MEMORANDUM

SUBJECT: SP-18-004 – Redtail Ranch
Second Submittal
Responses

Engineering Division

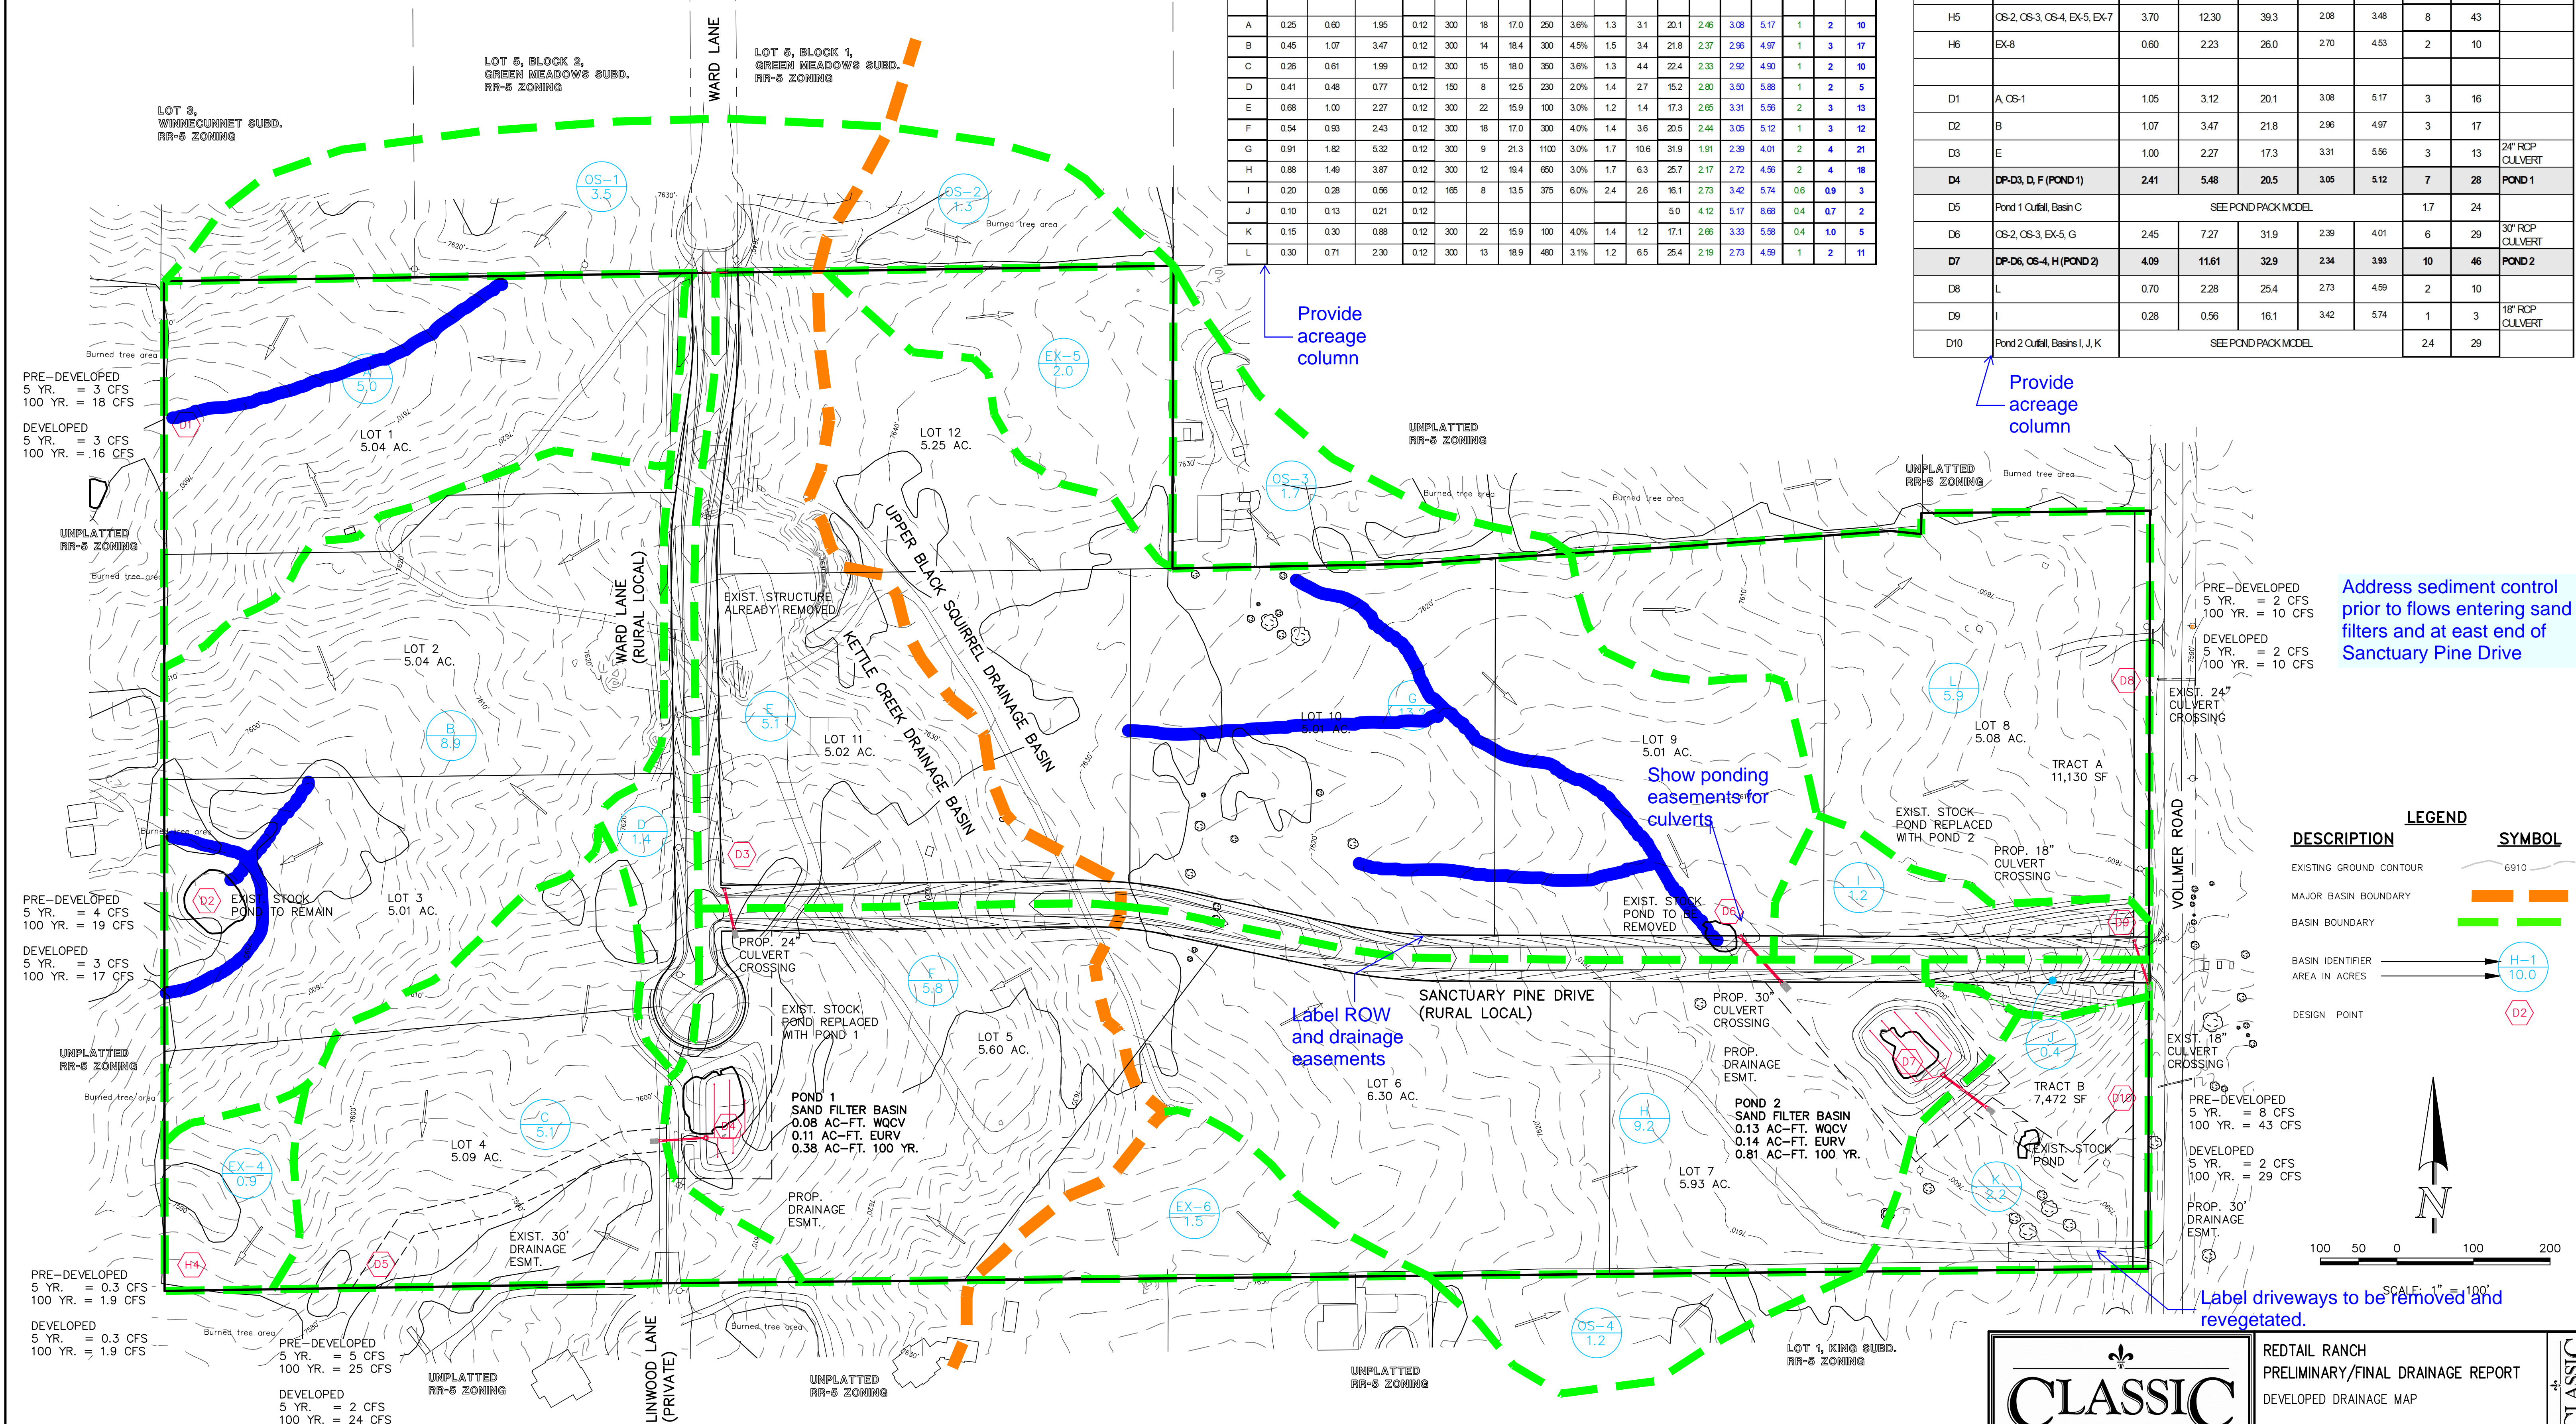
3. Address sediment control prior to runoff entering the Vollmer Road right-of-way and the proposed sand filter FSD basins. **Unresolved. Addressed. See additional design on the revised plans**
